**Interim Submission**  
**Pending resolution of issues associated with access to the**  
**Bay and Basin Leisure Centre precinct**

**SHOALHAVEN CITY COUNCIL**  
**ENVIRONMENTAL ASSESSMENT SUBMISSION TO THE NSW DEPARTMENT**  
**OF PLANNING**  
**PART 3A, ENVIRONMENTAL PLANNING & ASSESSMENT ACT, 1979**

**MAJOR PROJECT APPLICATION MP 06\_0205**  
**Modification No 2**

**PROPOSAL:** Proposed MP06\_0205 VDC Stage 1 - Modification No 2 being modification to the VDC Stage 1 approval by delivery of the VDC is two stages with Stage 1 now being approx 22,600m<sup>2</sup> and the future Stage 2, being approx 9400m<sup>2</sup> floor area, and associated arrangements; and the delivery of various off-site works before occupation of the VDC Stage 1.

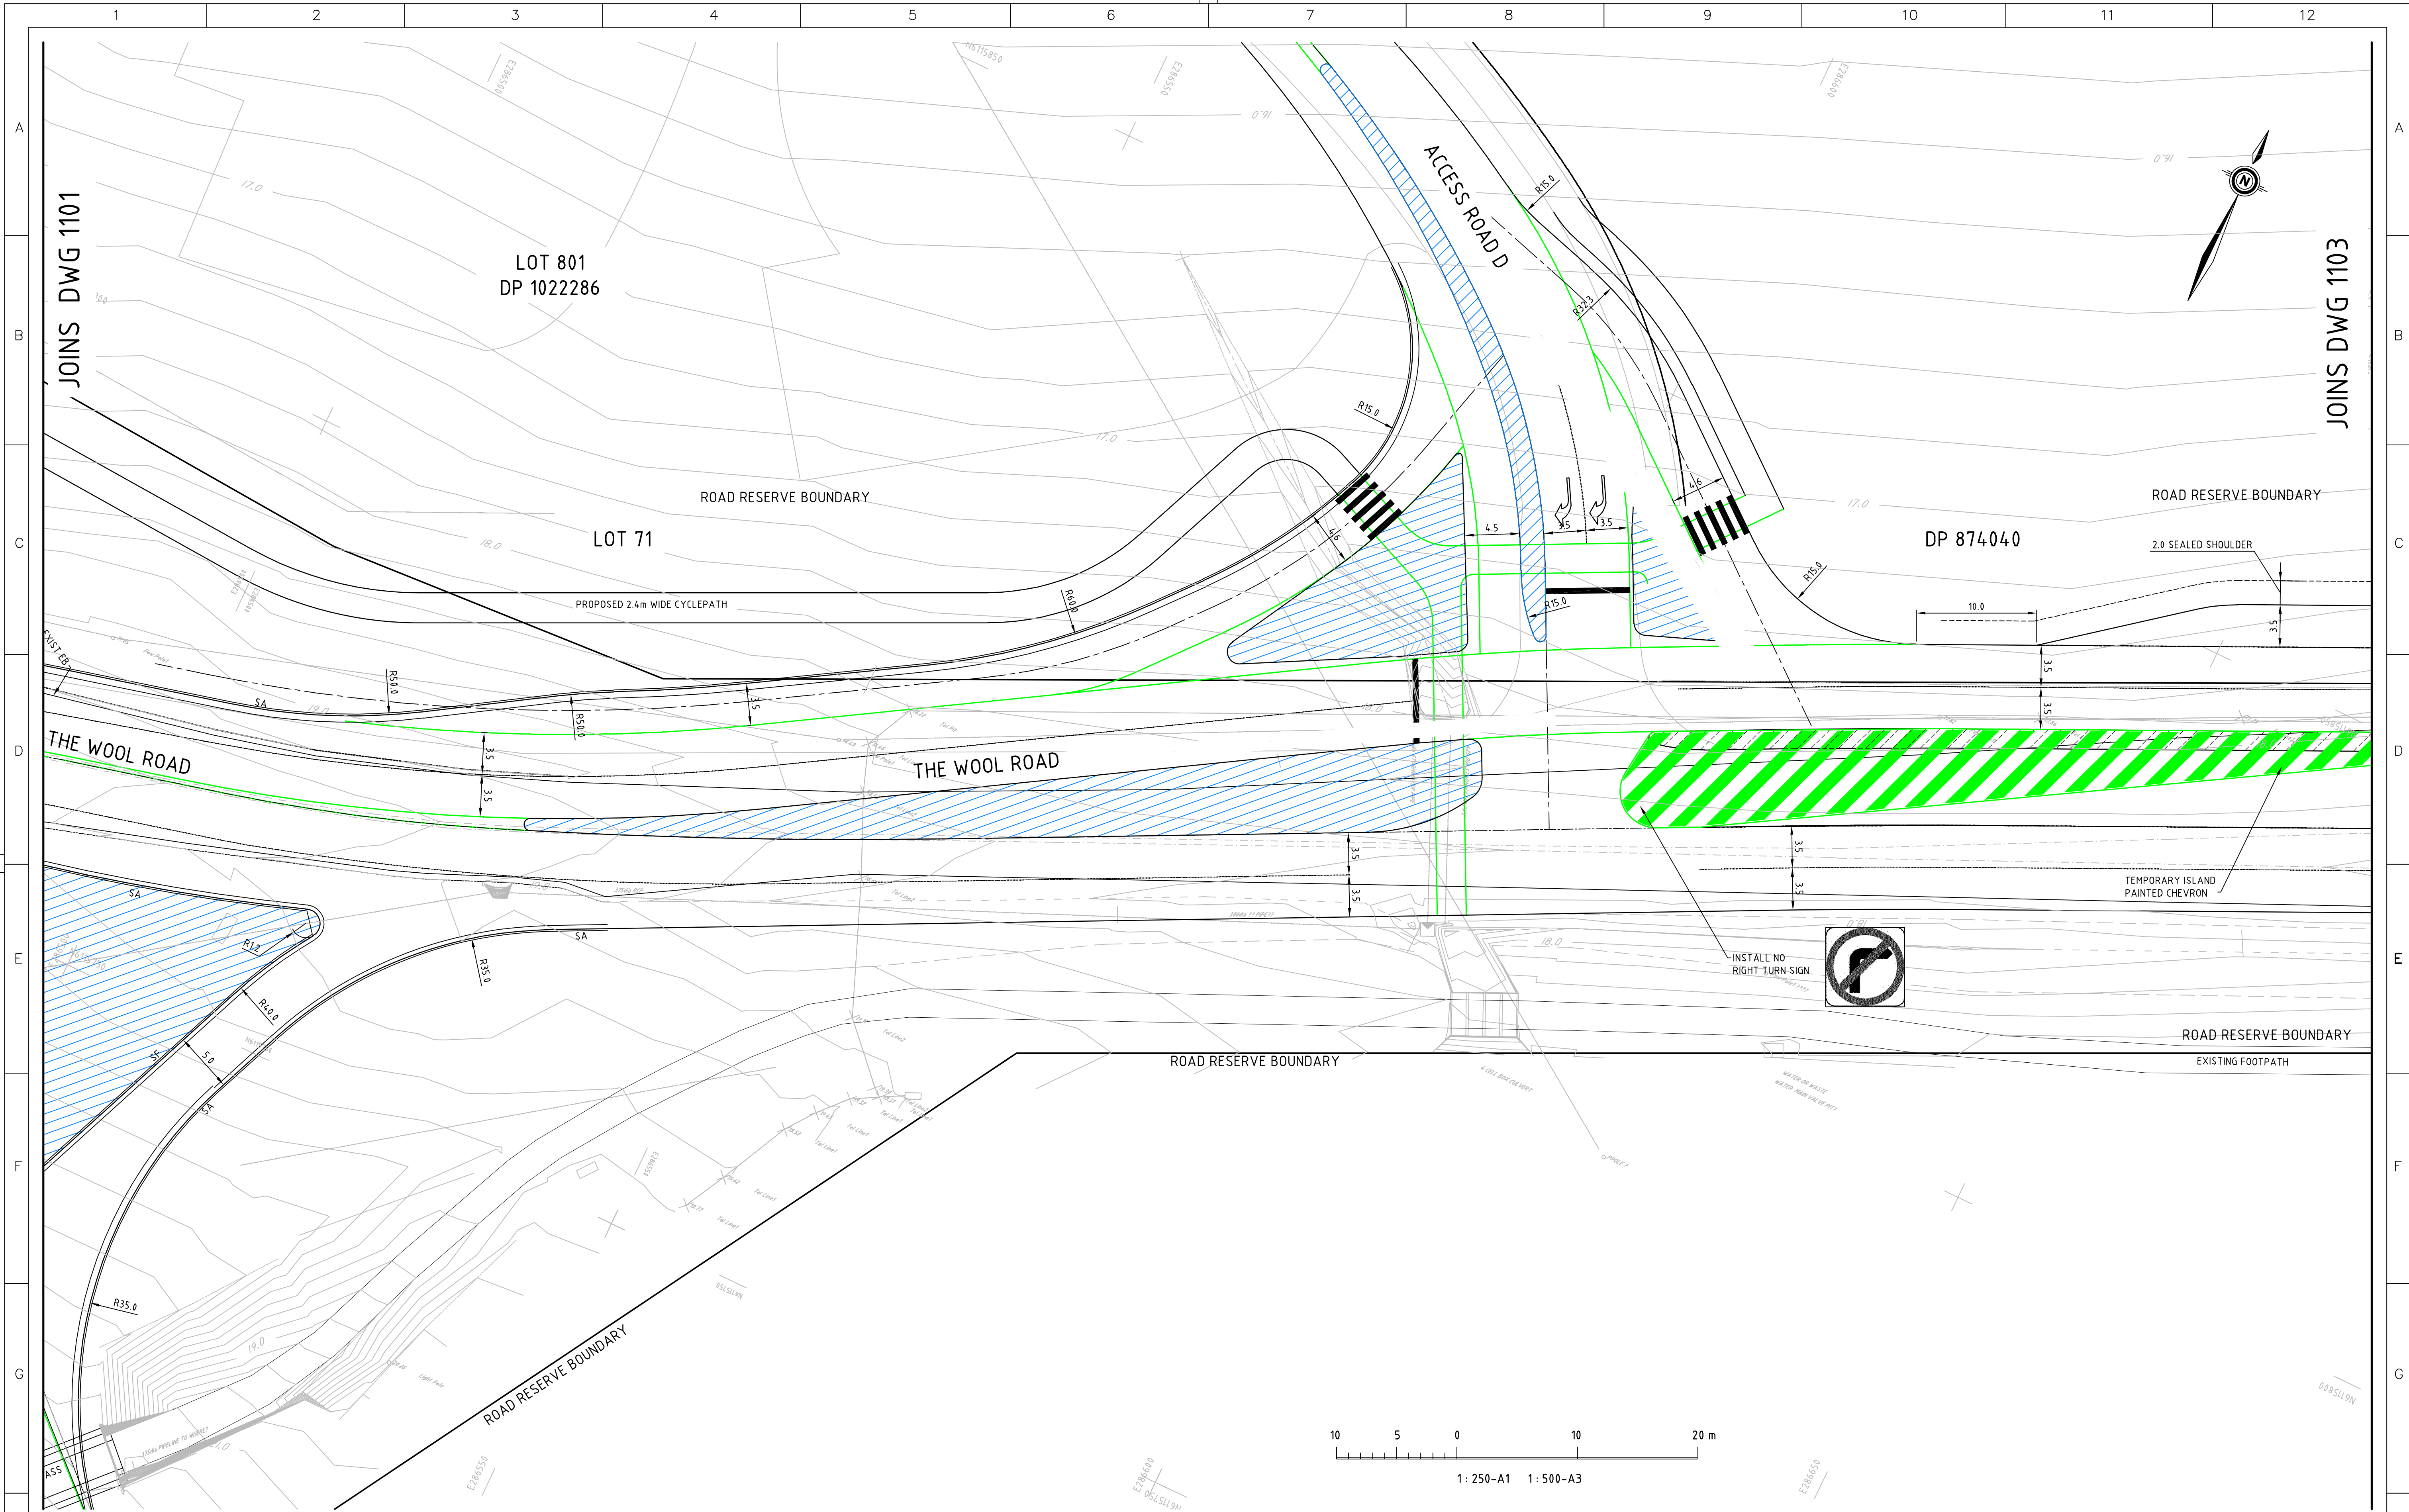
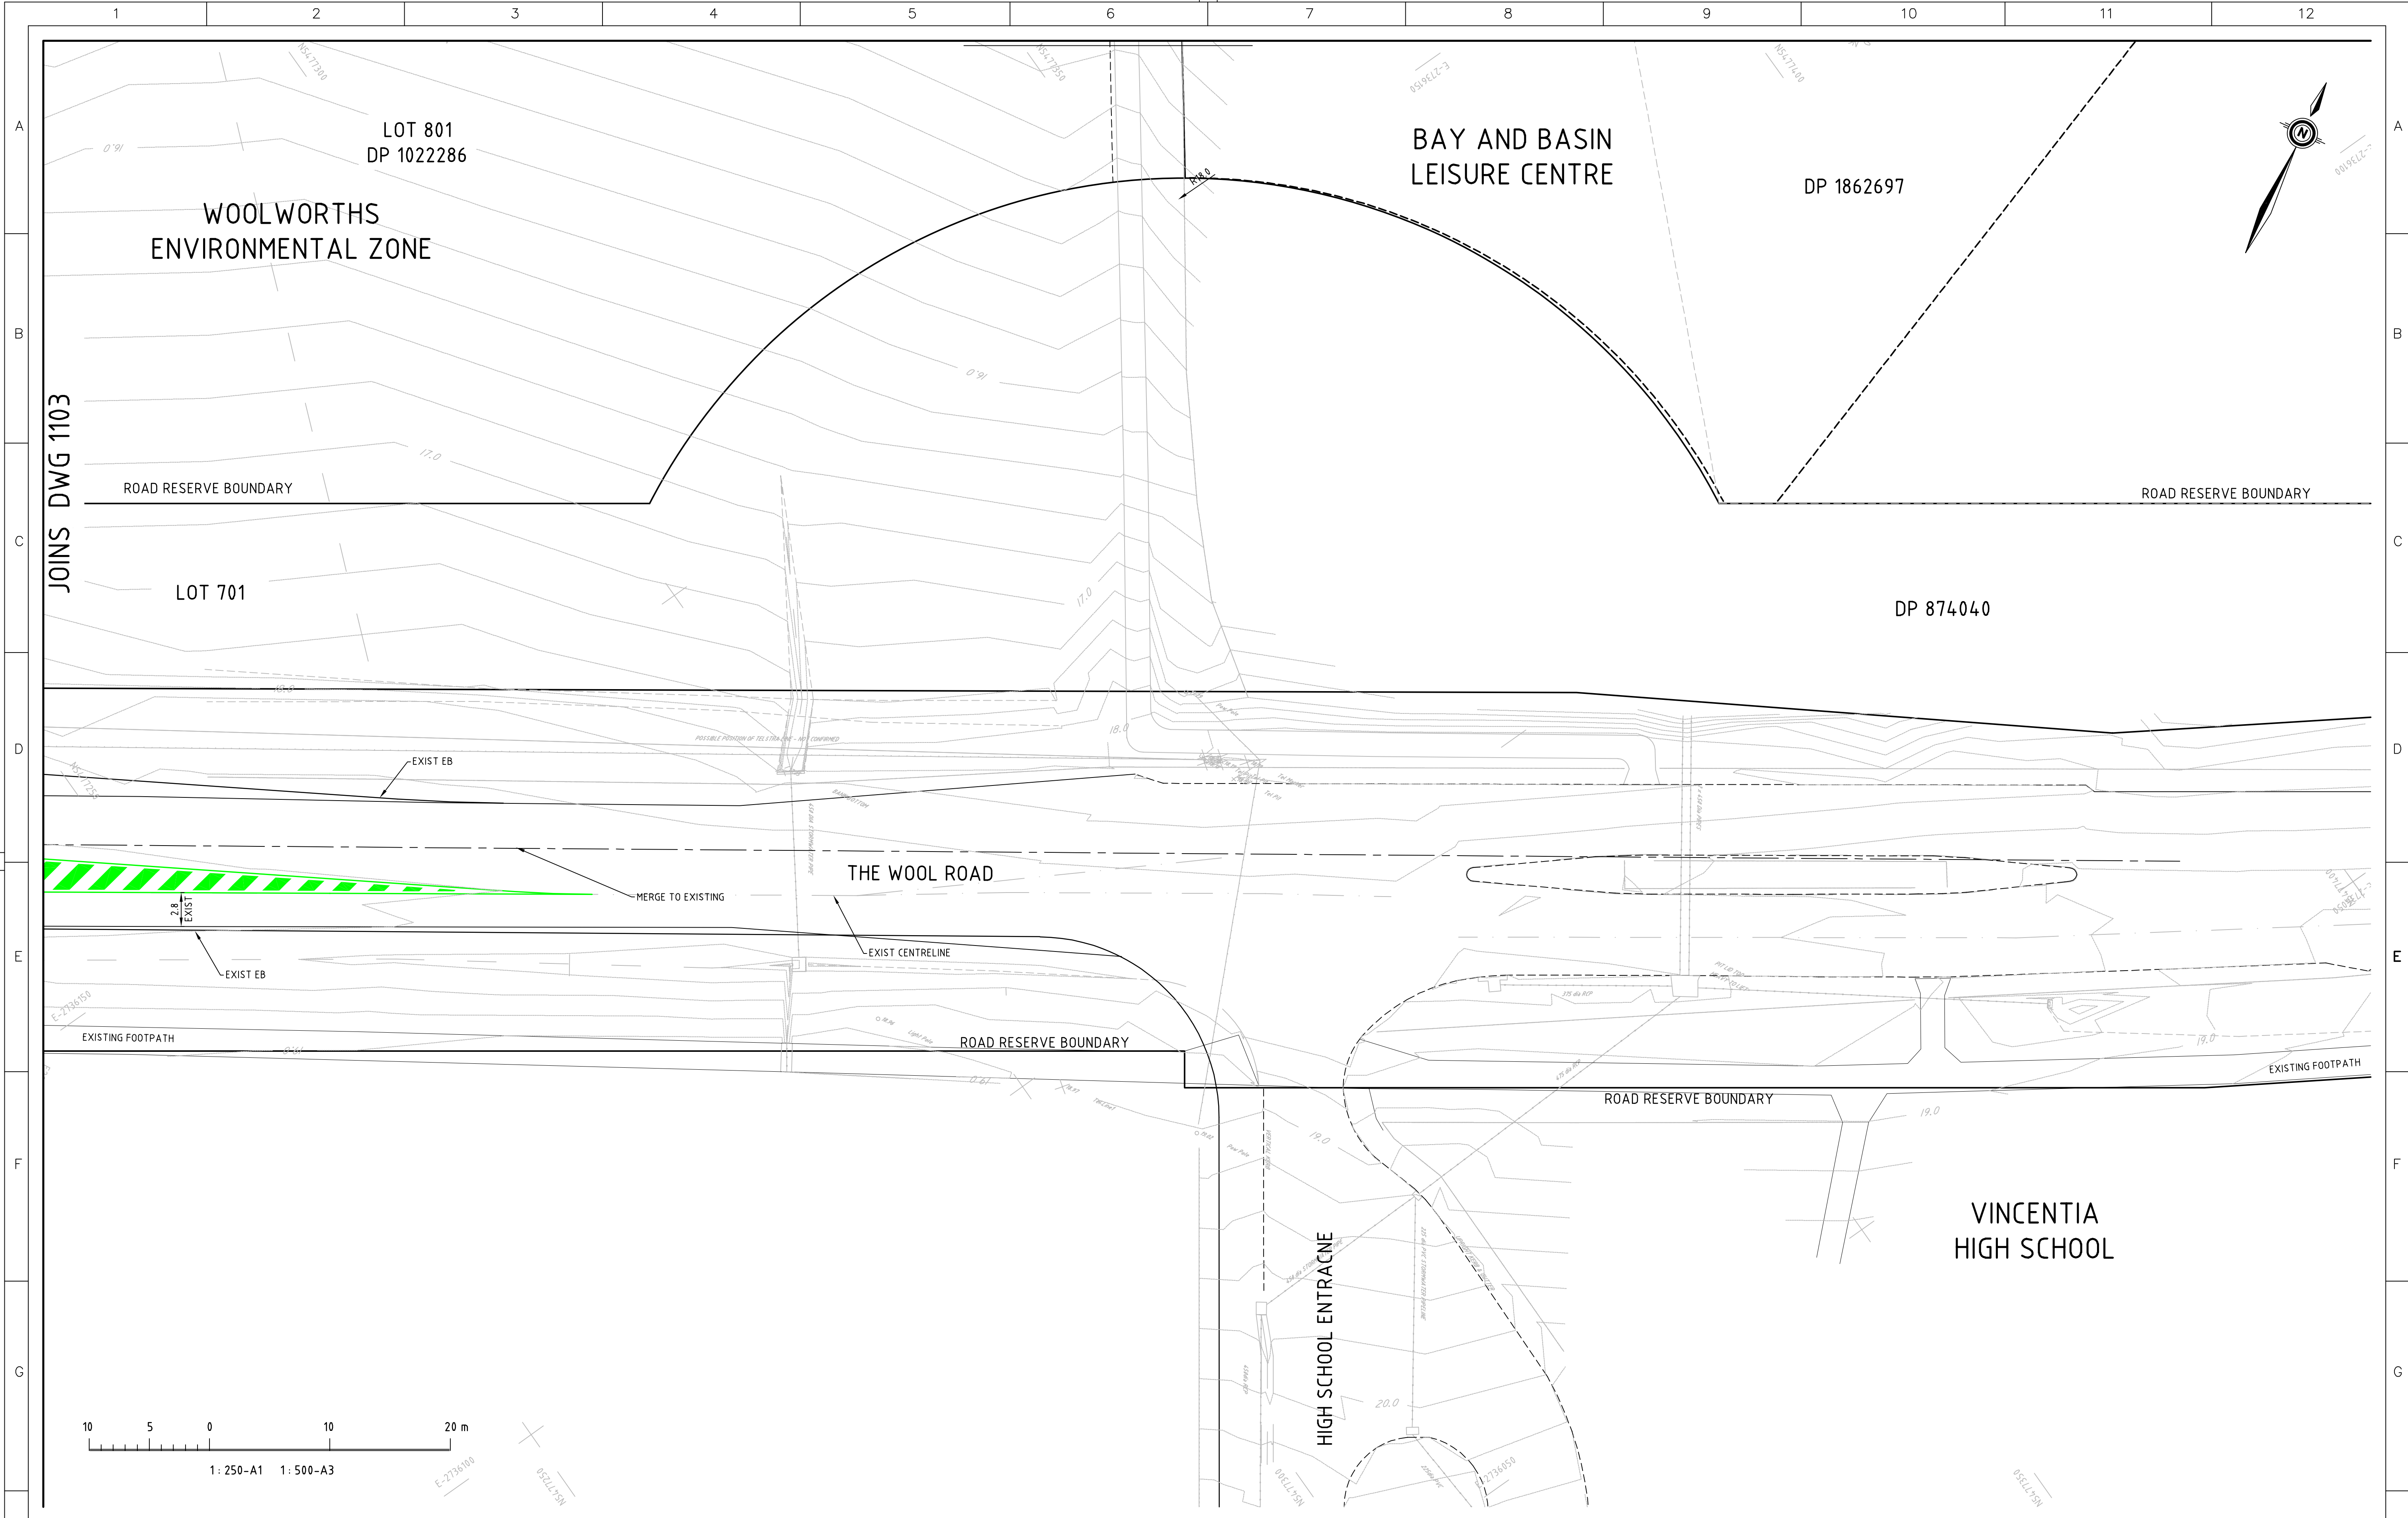
The design of a new road formation must take into account the constraints of the existing infrastructure in easements that exist and the final width necessary for two way movements and three lanes closer to the Wool Road ( similar to Cardno drawing 1010) will determine the reserve configuration. Council has provided comments on preliminary road designs that will be the subject of future consideration and referral to the Roads and Traffic Authority before determination and approvals are issued.
